From: Hannah Richmond [REDACTED]
Sent: 21 March 2022 15:44
To: Kathryn Welch <Kathryn.Welch@arun.gov.uk>
Subject: LU/27/22/HH

I'm the agent/architect for this application and wanted to write to you quickly about the application stated above for 103 Griffin Crescent.

PROPOSED SIDE ELEVATION

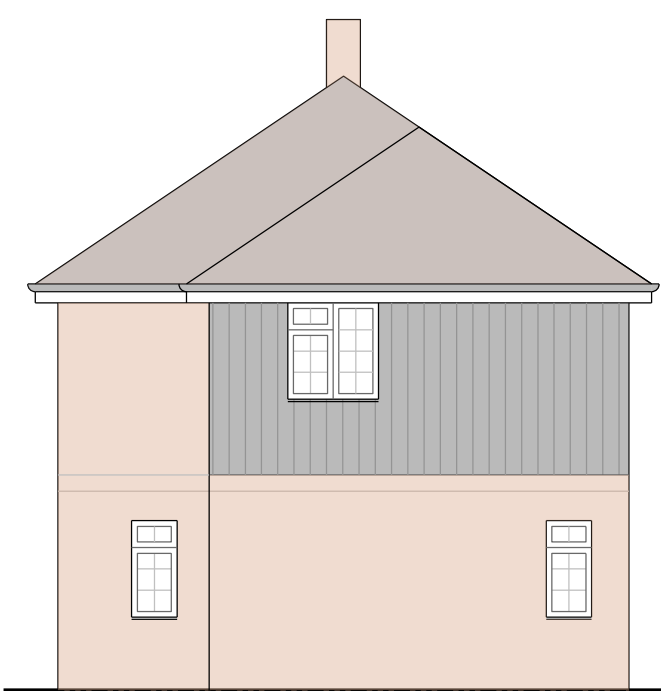
I note there's been a comment of objection regarding the side-facing windows. I would just like to assure you that these will of course be obscured glass. I am happy to reissue the drawing to clarify this if required although I anticipate it would be a planning condition in any case?
